TimberRidge Filing No. 2

Compensatory Mitigation Map

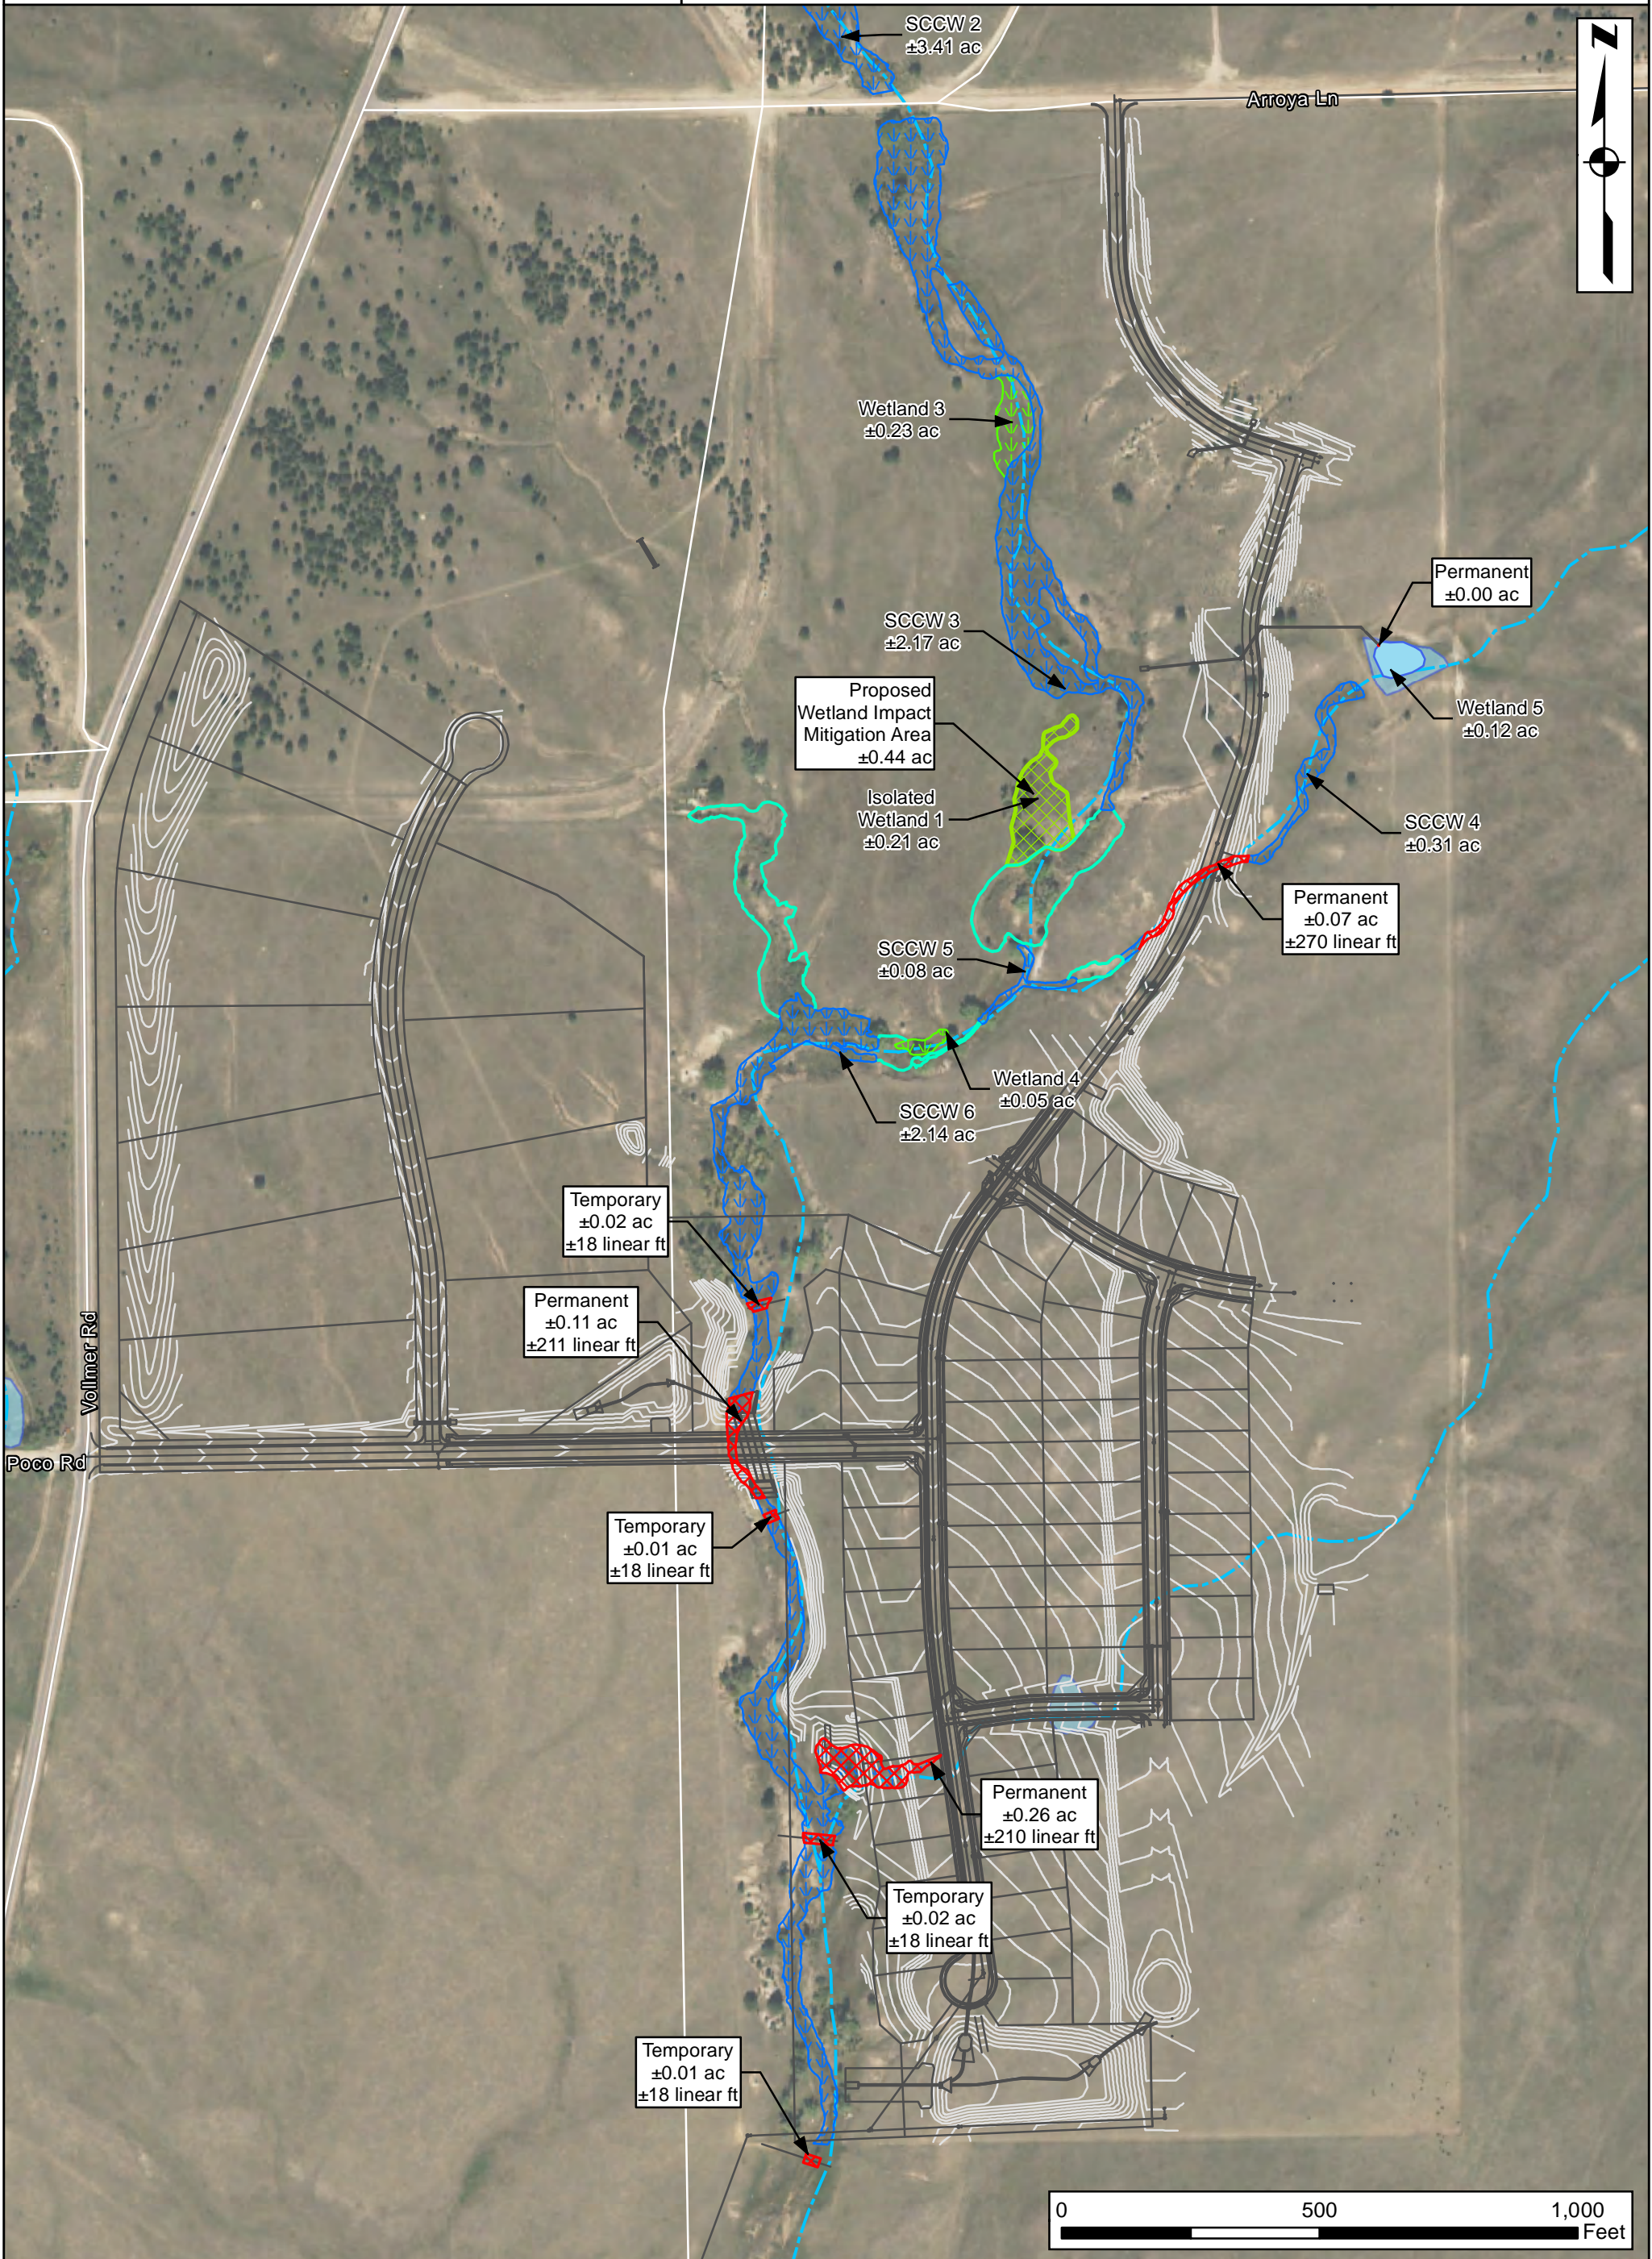
Verify specifically whether the wetlands in Tract B and to the north is being mitigated. Placing a detention basin in waters of the state is one of the issues in the EPA/CDPHE lawsuit against the City of Colorado Springs.

This Filing will require some drainage improvements within Sand Creek which will disturb wetlands as identified by the previous Wetlands Report. A wetlands mitigation plan will be submitted to the Corp of Engineers for review and approval. A copy of this wetlands permitting will be provided to County Staff upon completion.
